CITY OF ALBUQUERQUE

November 14, 2018

RE: **La Pasada Addition**
2206 4th NW
Grading and Drainage Plan
Engineer's Stamp Date 8/20/18
Hydrology File: H14D089

C-101

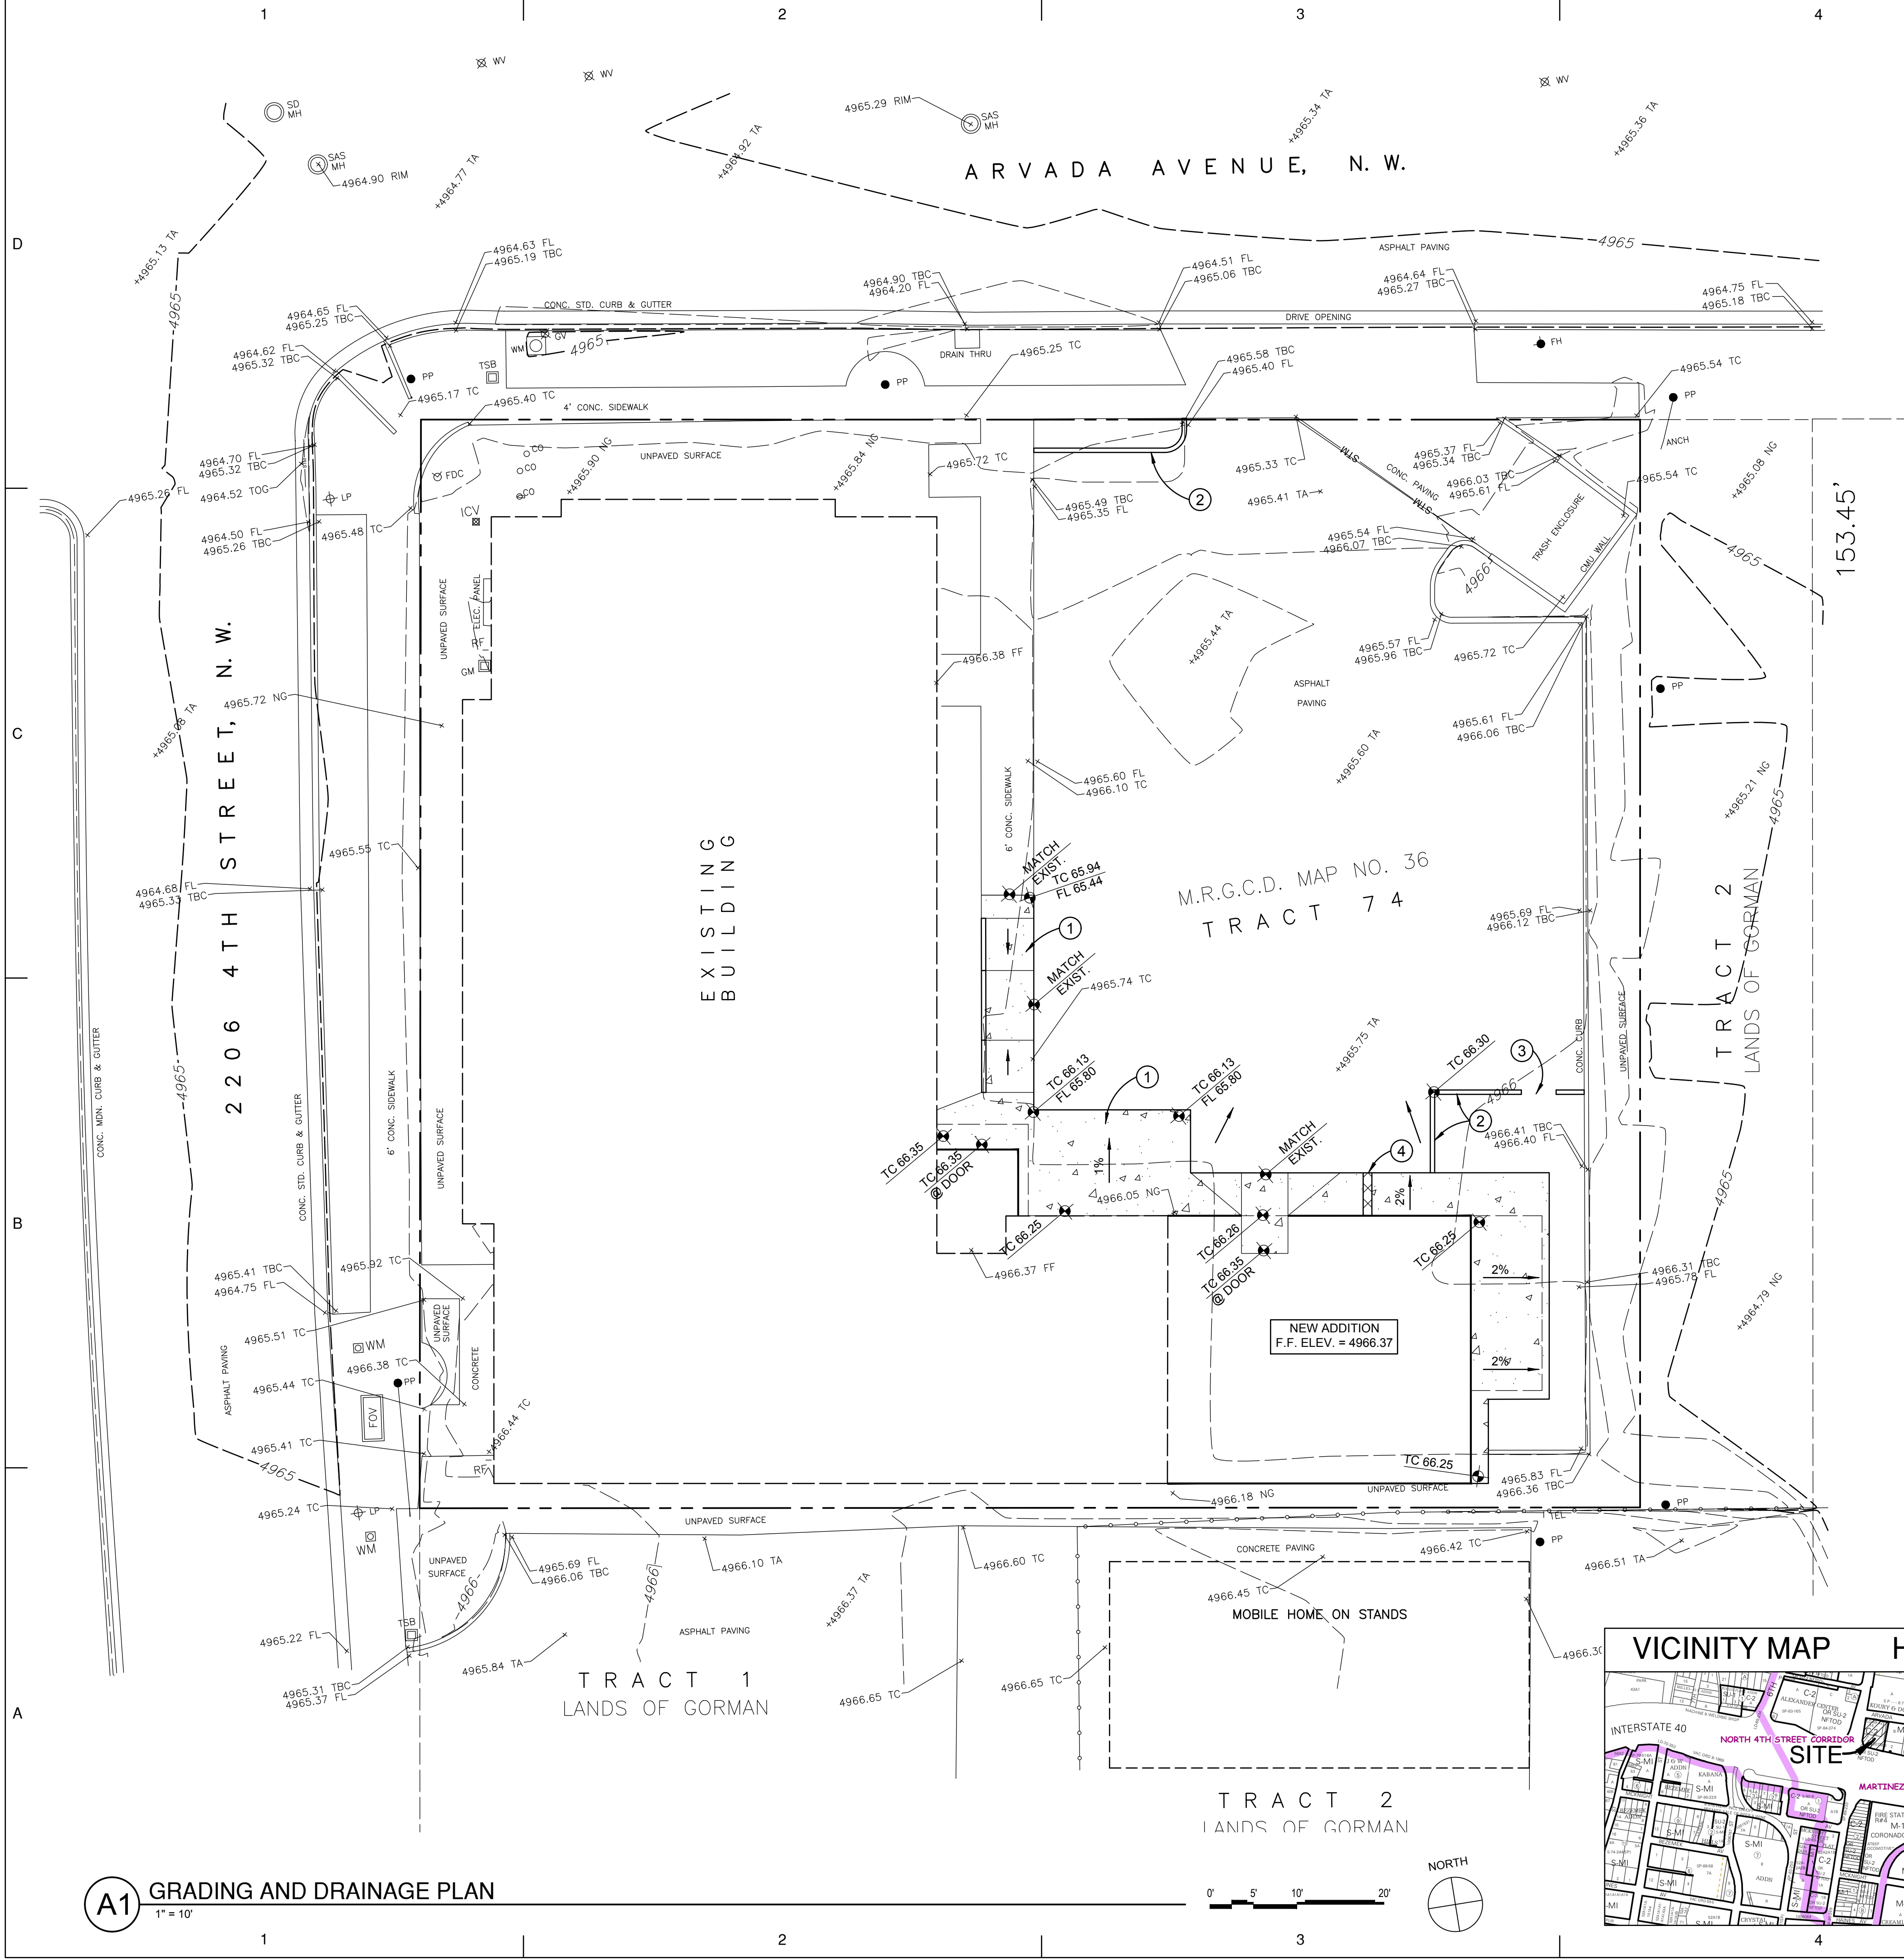
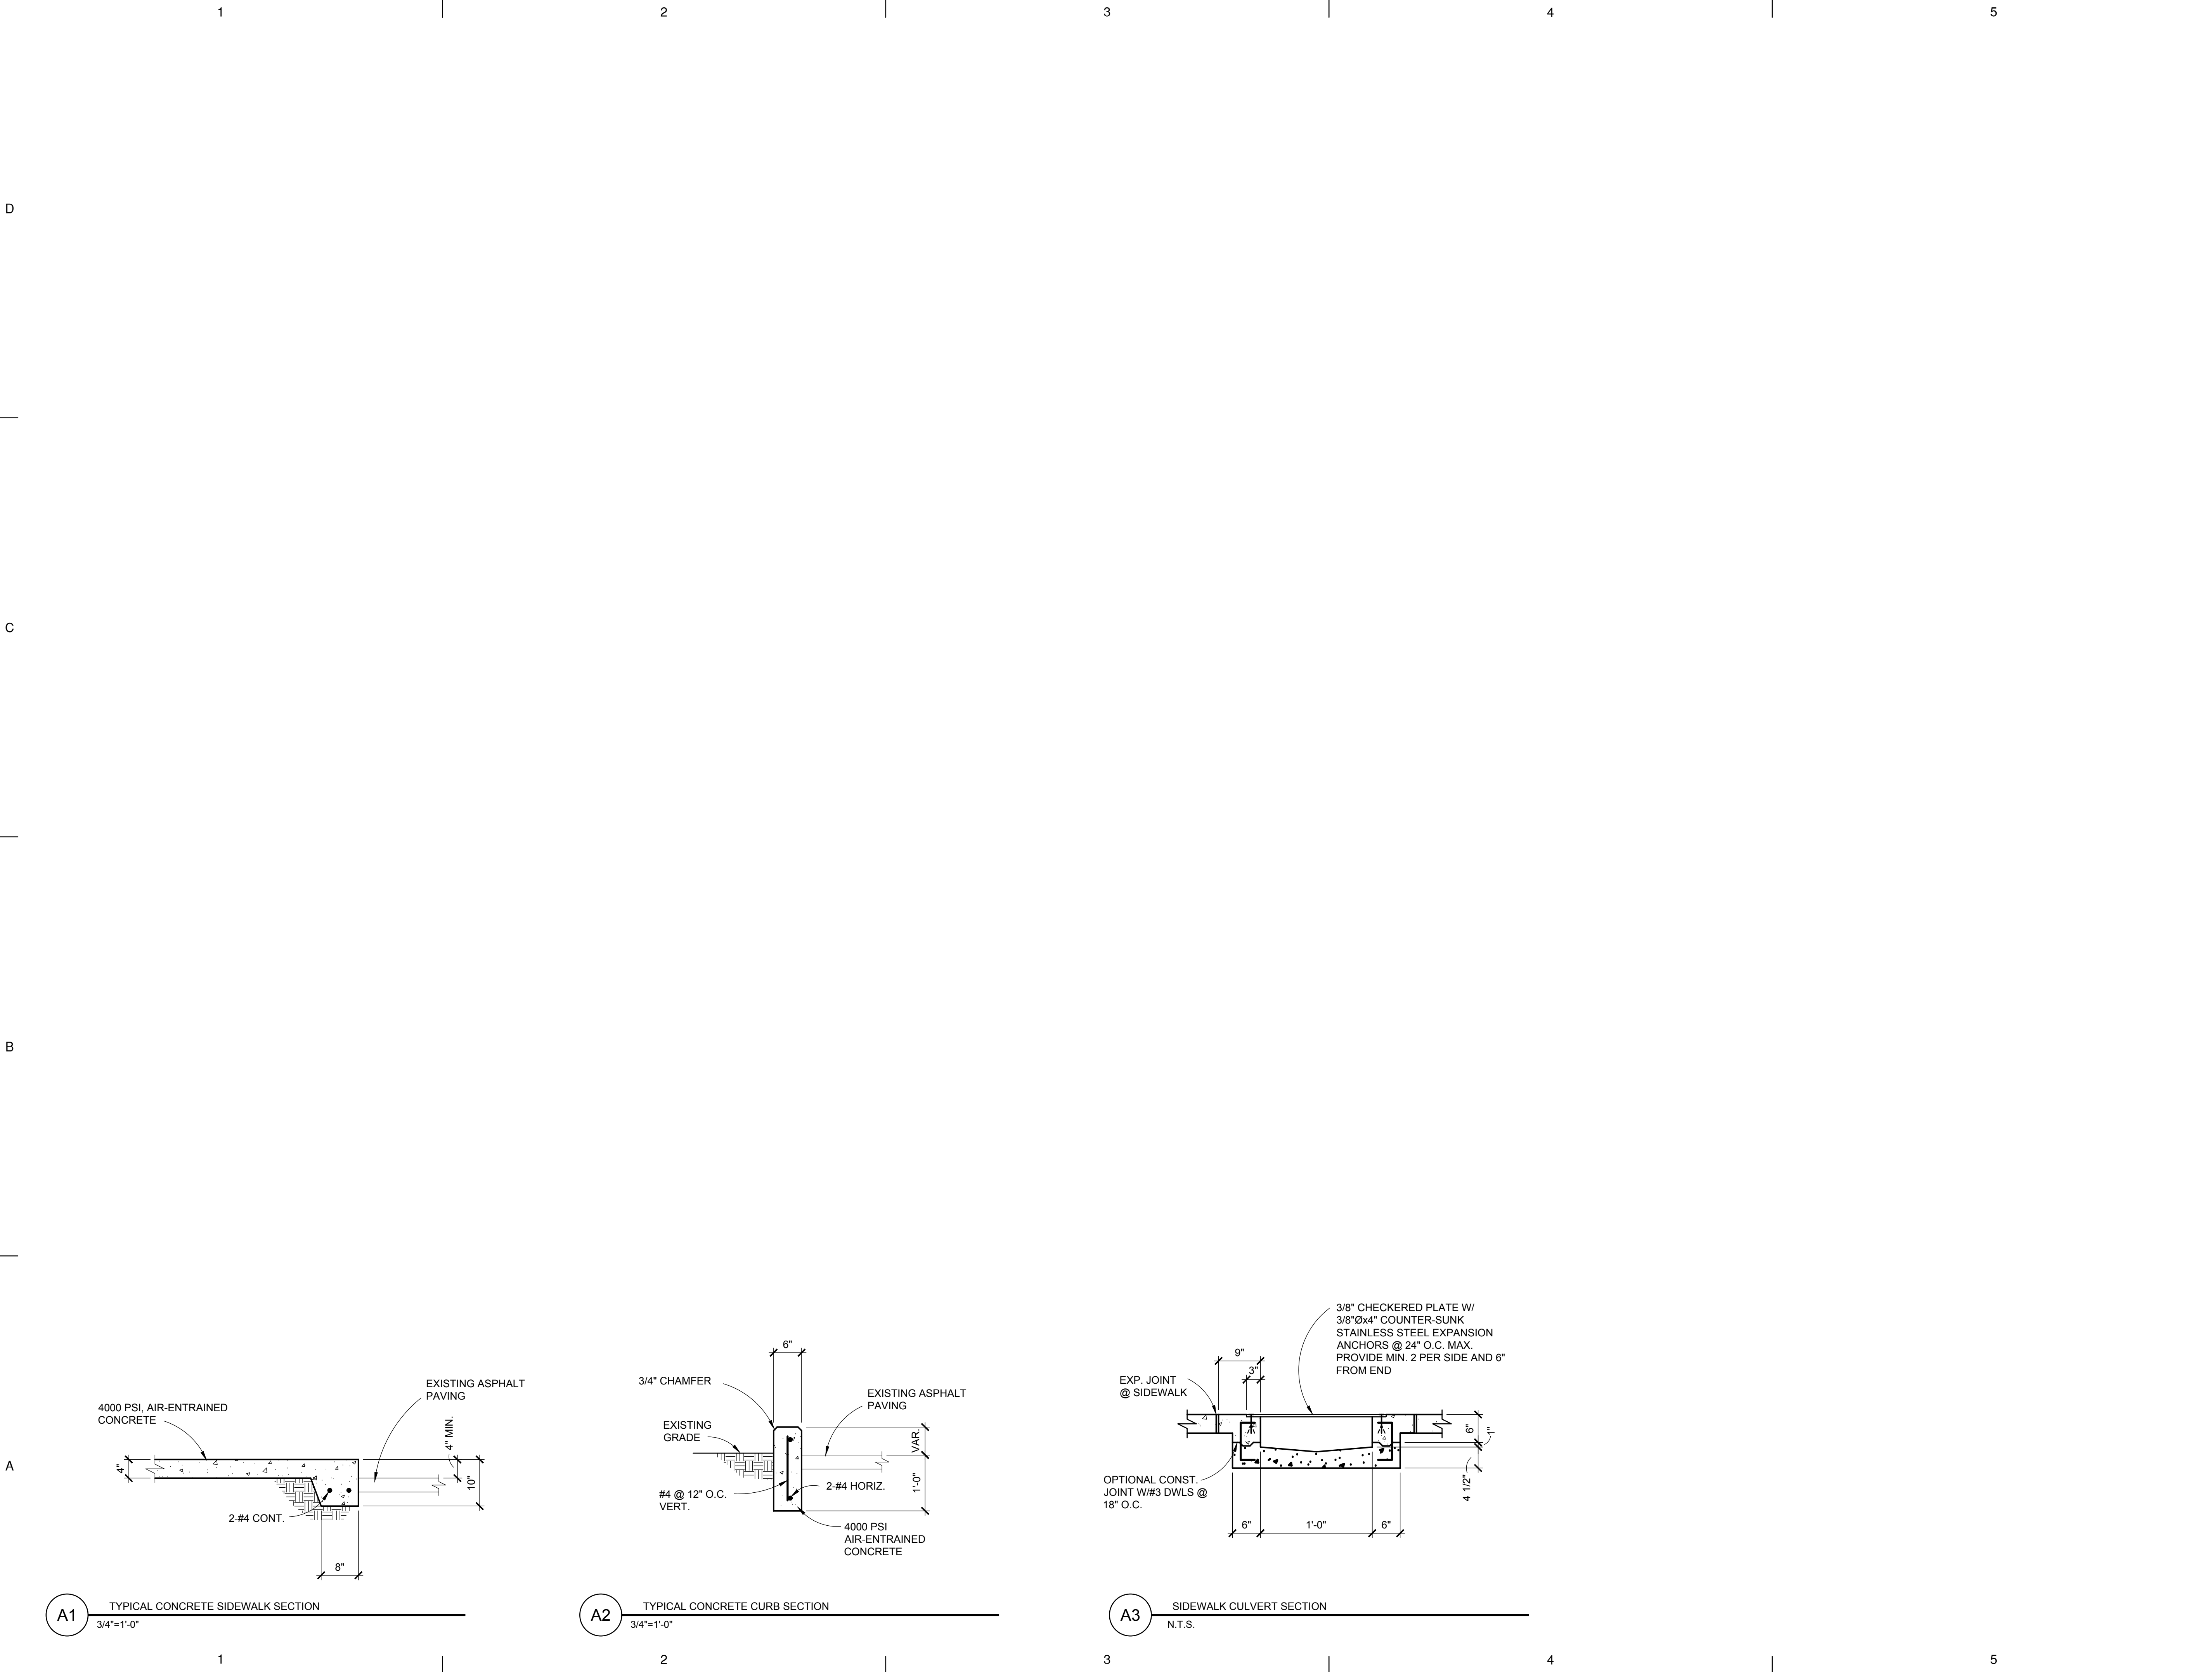
1. Payment of Fee-in-Lieu is required (Amount = 42cf x \$8/cf = \$336, per sheet C-101). Include the paid receipt in the resubmittal.
